Address: 18 Brook Meadows Huddersfield HD8 8GW

Application number: 2024/93458	
What is the application for?:	Erection of residential development for 62 dwellings including grouting remedial
Address of the site or building:	land at, Cliff Hill, Denby Dale, Huddersfield, HD8
Postcode:	YO1 0LT

Dwg No: 571/16(02)010P01

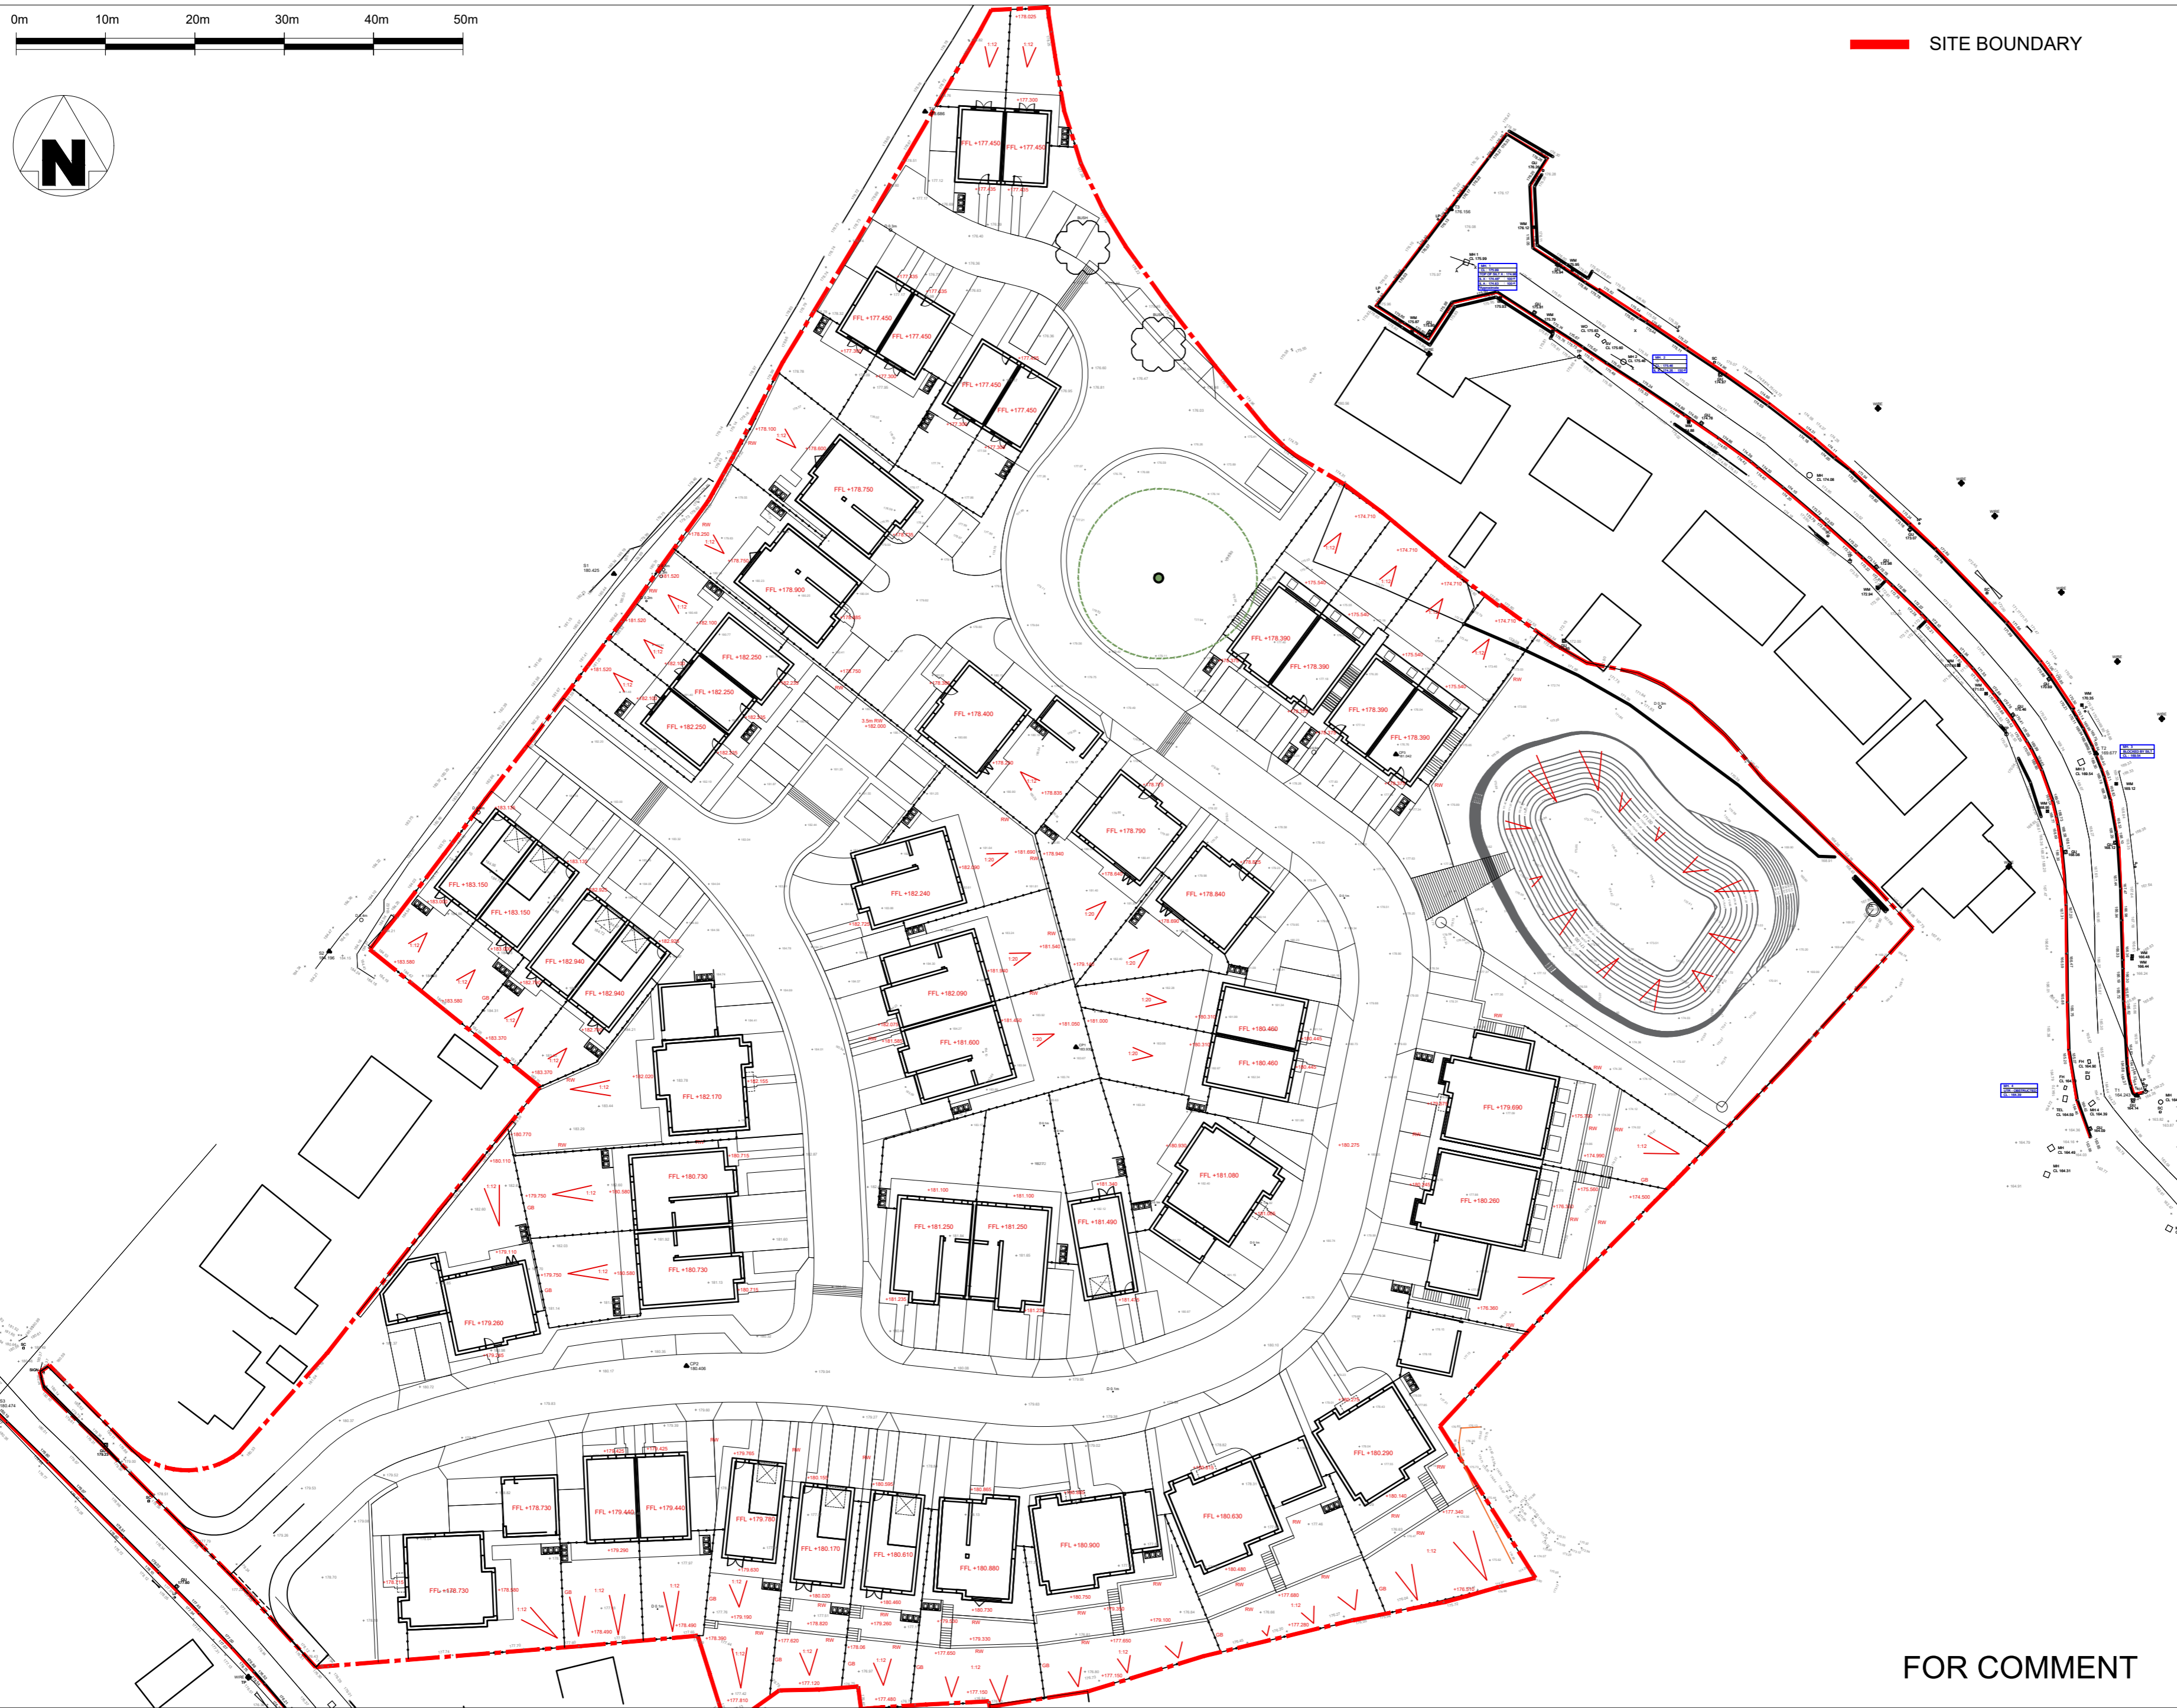
4.6 No grouting plan has been provided for the proposed layout. The figures and plan submitted relate to a development of 48 houses, previously rejected. The development will be at a substantial risk of subsidence as no grouting is proposed beneath private gardens and shared open spaces, and only some grouting is proposed beneath the development's estate roads. No mitigation for nearby properties is proposed.
